Appeal Decision

Appeal Ref: APP/R5510/D/24/3350421

74 Tolcarne Drive, Eastcote, Hillingdon HA5 2DG

- The appeal is made under section 78 of the Town and Country Planning Act 1990 (as amended) against a refusal to grant planning permission.
- The appeal is made by Mrs Gita Hirani against the decision of the Council of the London Borough of Hillingdon.
- The application ref is 8306/APP/2024/1179.
- The development proposed is described as “single storey rear and side extension”.

DRAWING NO. C55/74TOL/24/PL2

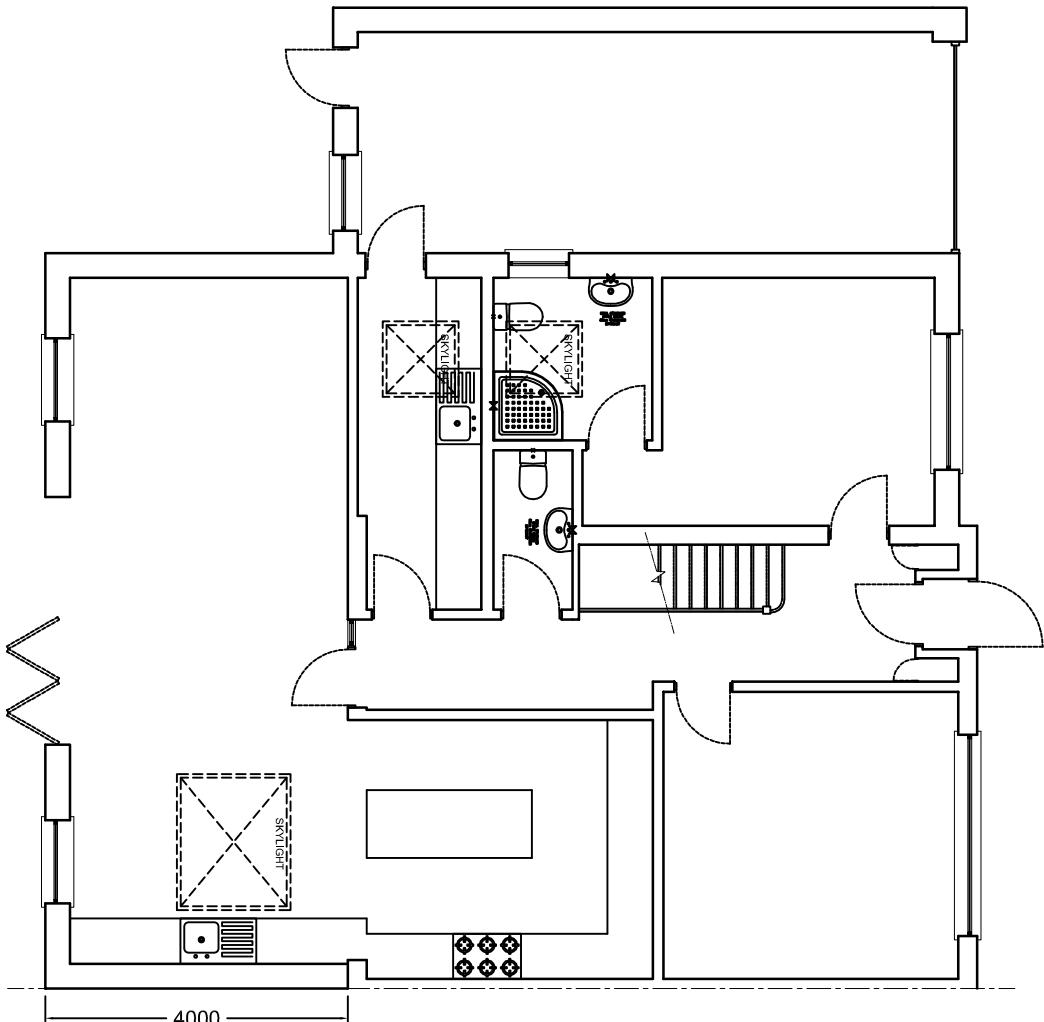
6. The Council have identified that the depth of the rear extension slightly exceeds the criteria contained within Policy DMHD 1 of the Hillingdon Local Plan Part 2 - Development Management Policies (2020) (HLPP2 DMP). However, the Council have confirmed that they consider this element of the proposal acceptable due to these types of extensions being a common feature within the area and the extension appearing as a subordinate addition that would not be harmful to the character of the host property and wider area. Based on the evidence before me, I see no reason to disagree with this assessment in relation to the rear extension.

7. In relation to side extensions, criteria C) i) of Policy DMHD 1 sets out that side extensions should not exceed half the width of the original property. The subtext of the policy confirms this is to ensure the size and width of an extension does not dominate the original property and to ensure the extension appears subordinate. However, I note that the wording of the policy does not dictate an absolute limitation on the width of an extension and does not account for the unique individual circumstances of each site.

8. In the context of Tolcarne Drive, the vast majority of properties extend to the boundary of their respective plots through single storey side extensions. Whilst the appeal site has an open frontage and the proposed extension would be wider than most within the area, it would extend to the boundary fencing and keep the plot open above ground floor level which would appear in keeping with the wider pattern of development.

9. Whilst I note that the height would be slightly taller than the original side extension, I am satisfied that the proposed side extension is of appropriate height, bulk and mass that would be appropriately proportioned to the site and would have a subservient appearance that would not dominate the host property. As such, the appeal proposal would be in keeping with the character and appearance of the host property and wider area.
